From: Sue Howell
Sent: 03 January 2018 17:15
To: Michael Eastham
Subject: RE: BN/28/17/RES - The former Lillies Caravan Park, Barnham

- I still remain to be convinced that a basin with a 1.0m depression taking the majority of the POS provides safe and useable POS? I would recommend that now that this detail has been supplied that it is run past our Drainage Engineers for their view on the 1 in 100 year storm event scenario and whether they concur that this area would otherwise remain dry in reality? I now refer this to them for an expert opinion.

scheme: The Lillies, Yapton Rd
Barnham
client: Matthew Homes
drawing: Landscape Proposals
date: April 2017
scale: 1:200@A1
drawing no: MAT21212 11E sheet 2
drawn: AE checked: DKM

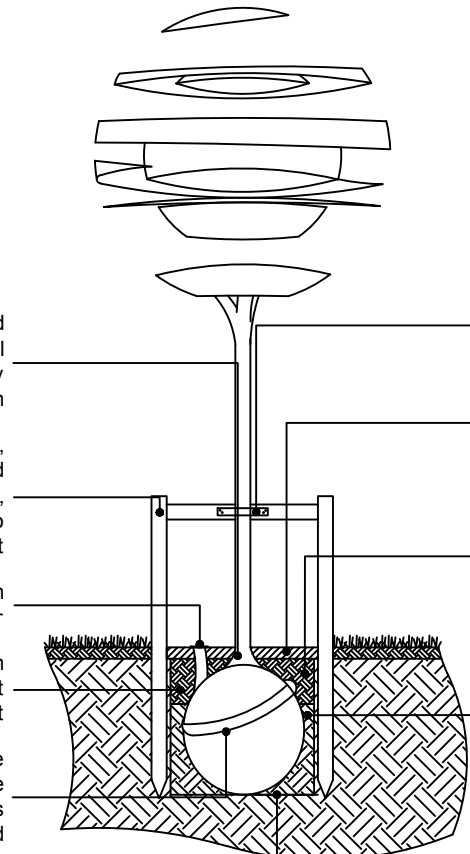
- The repositioning of Block A I feel has just shifted the issue not resolved it. The omission of Block A would be a better outcome.
- The drawing MAT21212 11E Sheet 2 now details Informal play space adjacent to the SuDS depression. The requirement for this site regarding play is for on-site LEAP, detail of this has still not been provided or detail of such specified ('informal play' annotation does not provide this detail) Please therefore ask for the detail of the play offer detail; as previously requested below, to be provided.

scheme: The Lillies, Yapton Rd
 Barnham
 client: Matthew Homes
 drawing: Landscape Proposals
 date: April 2017
 scale: 1:200@A1
 drawing no: MAT21212 11E sheet 1
 drawn: AE checked: DKM

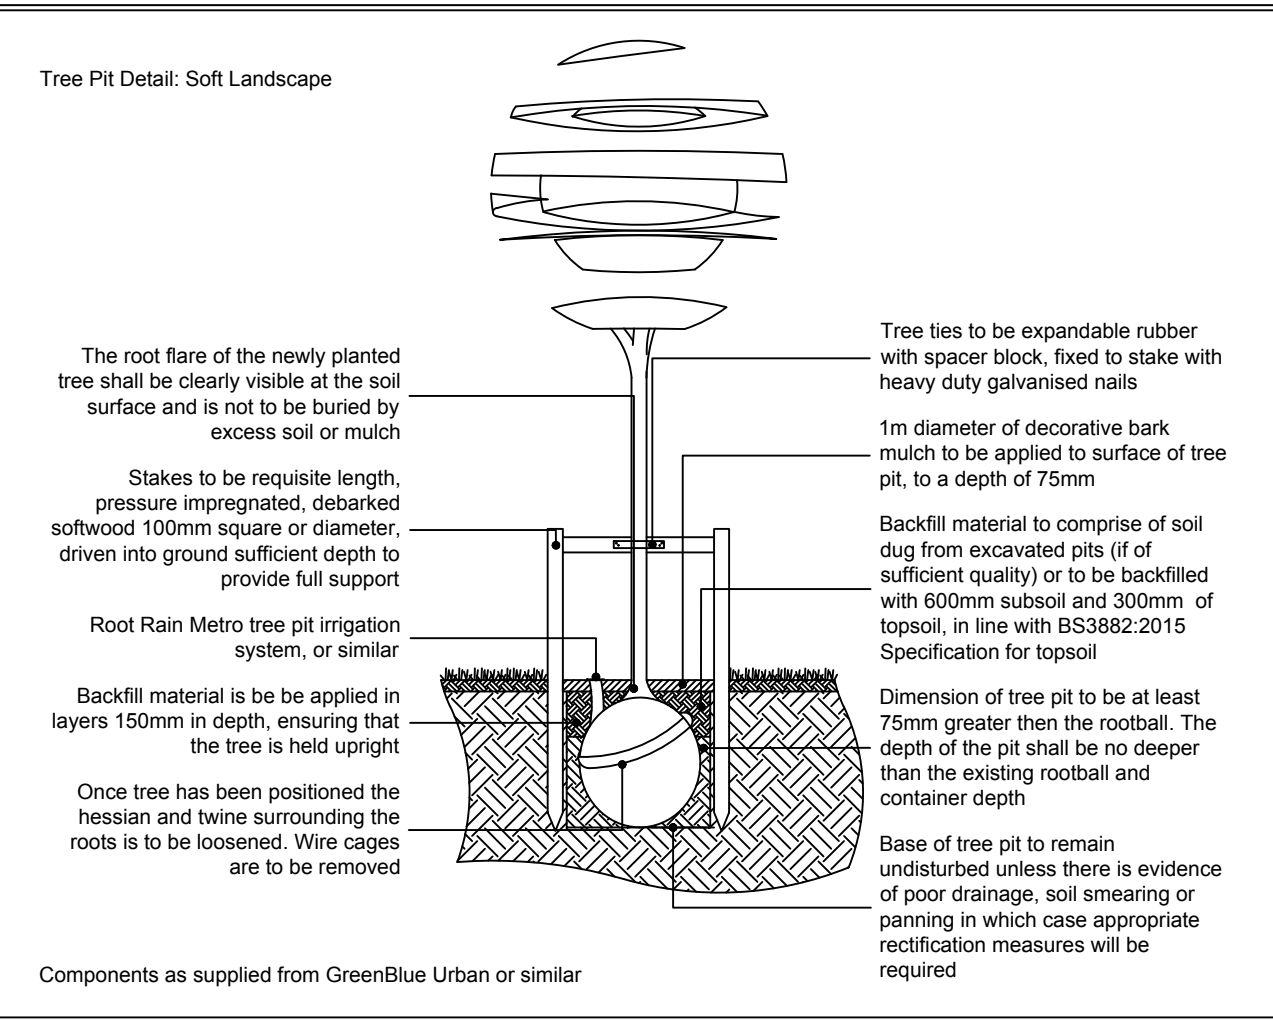
- I note that the proposer has suggested 'Attenuation basin shape revised and relocated to south western corner' please can you request a copy of cross section through this area so that the basin shape in relation to the repositioned apartment block can be viewed as proposed build?
- Please can they also confirm where the play offer is to be sited in relation to the open space on the site?

- Landscaping drawing 11E-sheet 1 & 2 demonstrating the position of informal play area
- Drawing No. 17748-5-SK003, Section illustrating the cross-section of the basin in relation to the apartment block.
